10669 Land at Bicester Road, Kidlington

Technical Note 9 Rv1: Drainage Response to Council Comments

9th June 2022

Figure 5-1: EA Flood Zone Plan showing 1 in 100 & 1 in 1,000 year floodplains

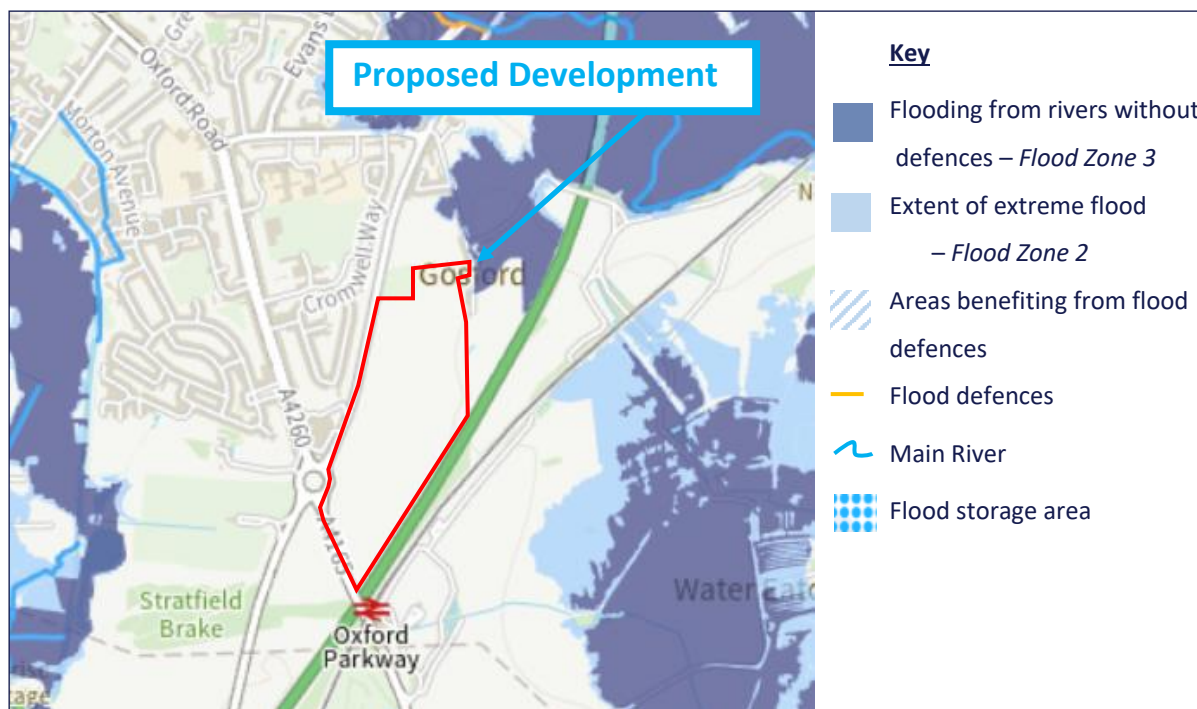
- 3.2 *Flood Risk Assessment Fluvial Impact Table 5.1. The potential for fluvial impact is said to be none but the commentary suggests that there is potential. I assume this is a typo but please clarify.*

- 3.3 The site does lie entirely within Flood Zone 1, therefore there is no risk of fluvial flooding. The flood extent from the River Cherwell is adjacent to the site boundary, but does not impact the site. The word potential can be removed so that the sentence will say 'the River Cherwell is located approximately 550m north east of the site and its associated flood zone lies outside of the proposed development'.

Figure 5-2: EA Long Term Flood Risk Maps – Flood risk from Surface Water (Gov.Uk website)

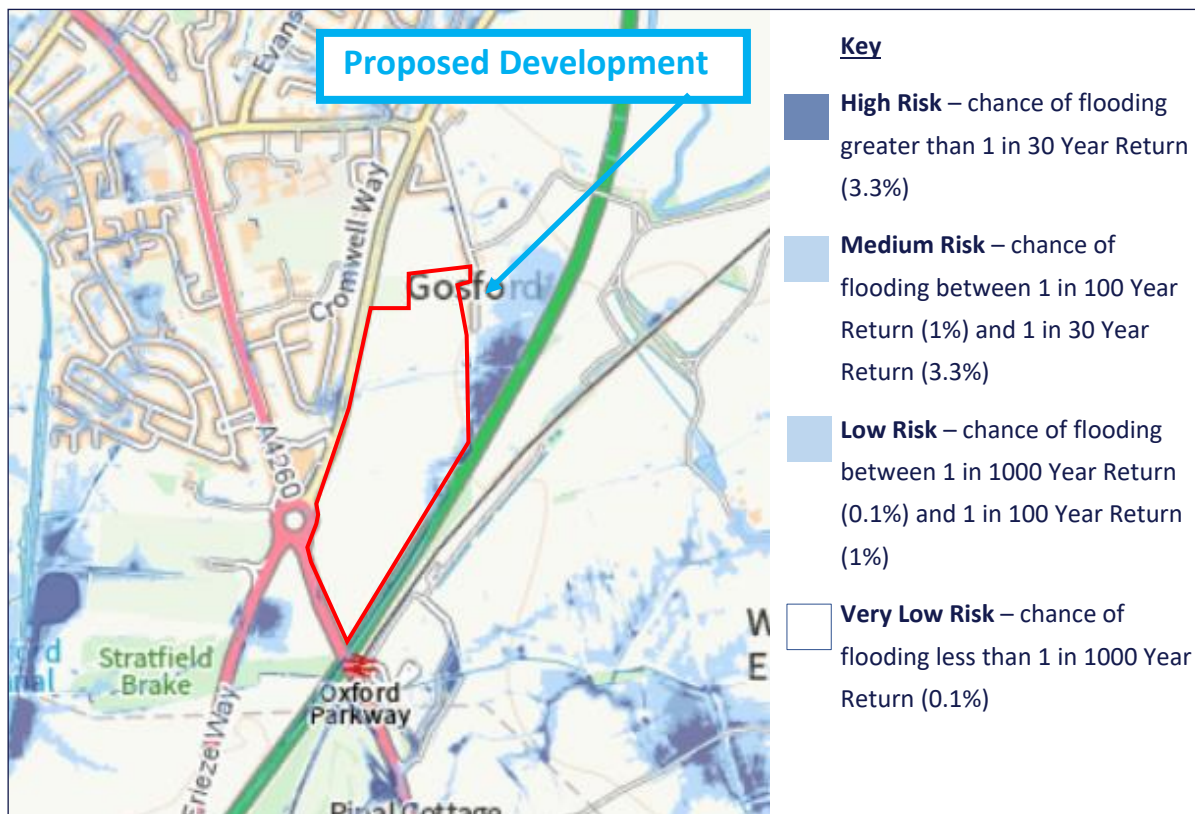
- 3.4 *Flood Risk Assessment Para 5.4. Small areas of the site are shown to be at surface water flood risk. Local mitigation is required to relieve this.*

- 3.5 The proposed SuDS network will attenuate all surface water runoff from the development site. This will remove the low risk of surface water flooding along the eastern boundary of the site and relocate the volume of ponding into the SuDS basin.

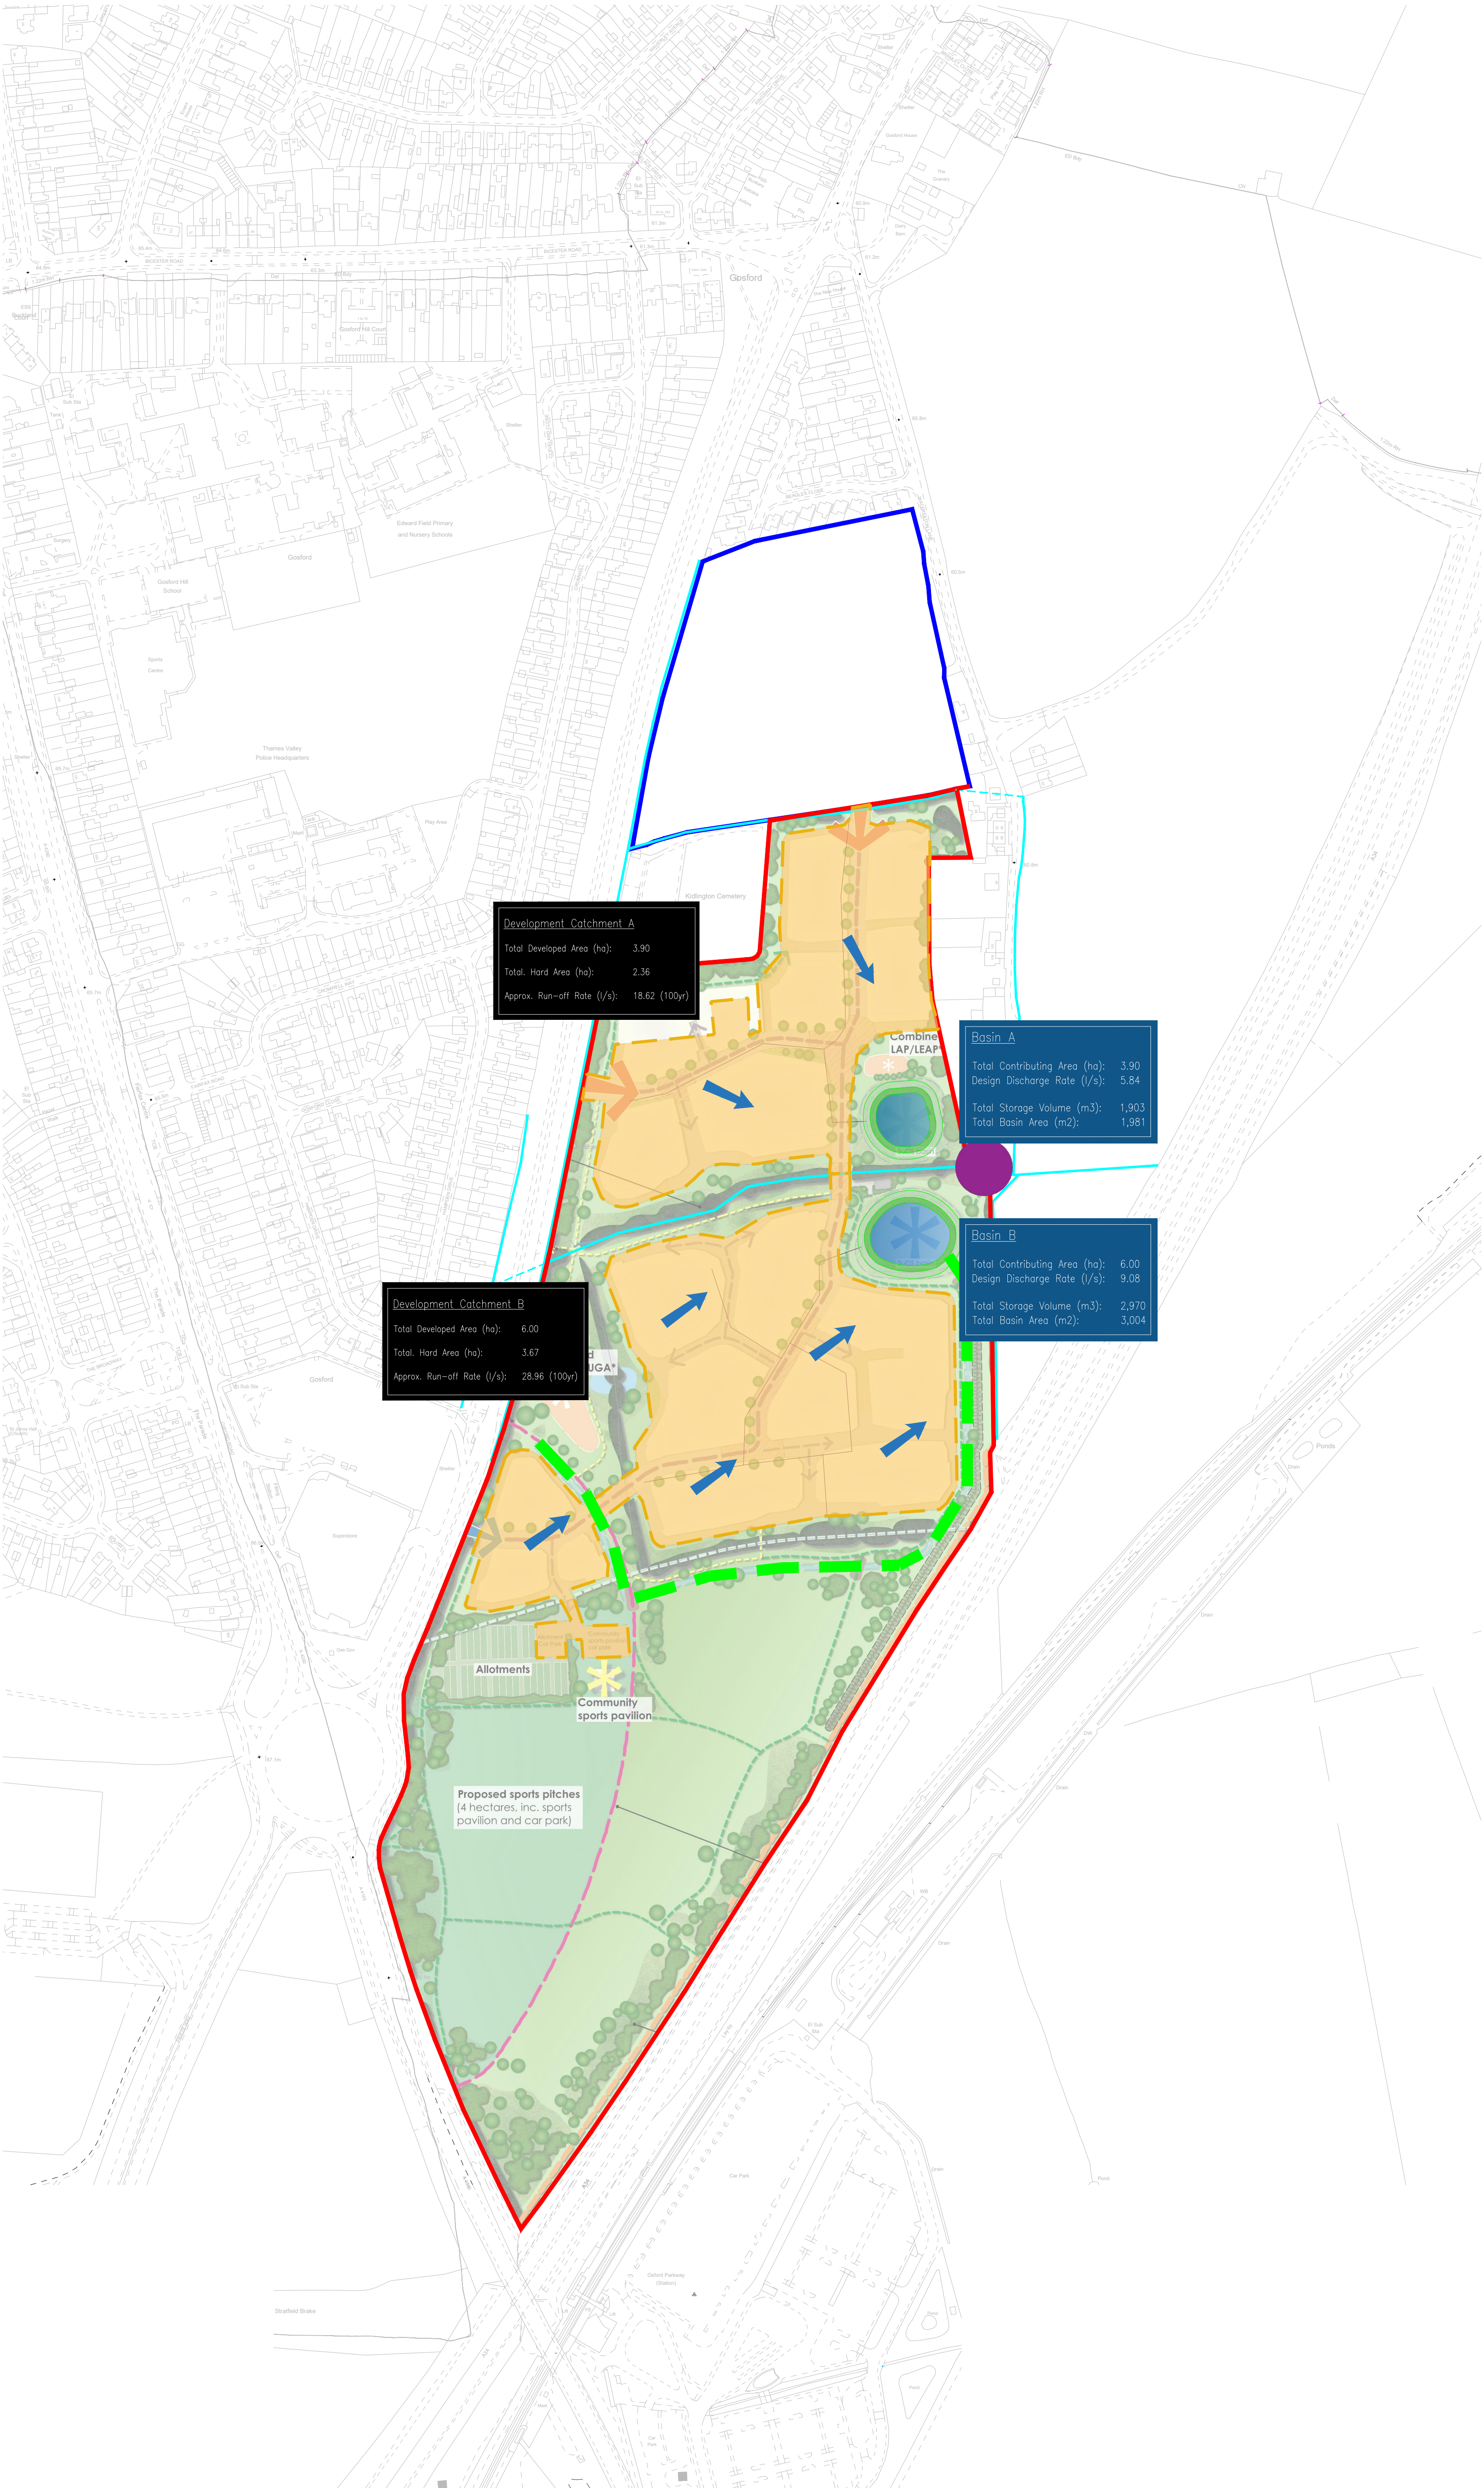
- 3.6 *Flood Risk Assessment Section 7. It is noted that the site is necessarily divided into two sub-catchments. The plan at Appendix A shows two single point attenuation basins, one for each sub-catchment. Whilst this is technically acceptable it is not in compliance with Oxfordshire Local Policy which seeks linear attenuation in preference.*

- 3.10 *The Council will be seeking to achieve as much open channel surface water drainage as is practical to reduce the extent of piped surface water sewerage. The Council will be further seeking to have these linear corridors within suitably wide open spaces so that they can be readily maintained and the open space adopting*

Authority will become the riparian owner. If single point attenuation basins are accepted, notwithstanding the above comment, these too should be located in adoptable open spaces so that they can be readily maintained by the adopting Authority.

- 3.7 Basin A has been designed to fit into the topography of the site. If the basin were to become a more linear feature along the eastern boundary, it will require unnecessary and extensive earthworks and negatively impact the development area.

- 3.8 Basin B could be elongated in some form along the eastern boundary where the proposed swale feature is currently illustrated. This can be explored in greater detail through the reserved matters submissions, after the outline permission is granted. There will be a condition attached to any grant of outline planning permission which will require submission of a detailed drainage scheme for approval.

- 3.9 Both Basins A and B cannot become linear features that run parallel to the onsite watercourse as this would impact the location of where the spine road would be able to cross the watercourse and connect the two residential parcels. The road is currently located in the east of the development site in order to fulfil the Council's now approved Development Brief.

- 3.11** A main conveyance channel has been proposed within Catchment B, to provide some additional open channel drainage. At reserved matters additional conveyance features can be included within the design, where possible to reduce the piped network, with over the edge drainage where roads are not fronted on both sides.
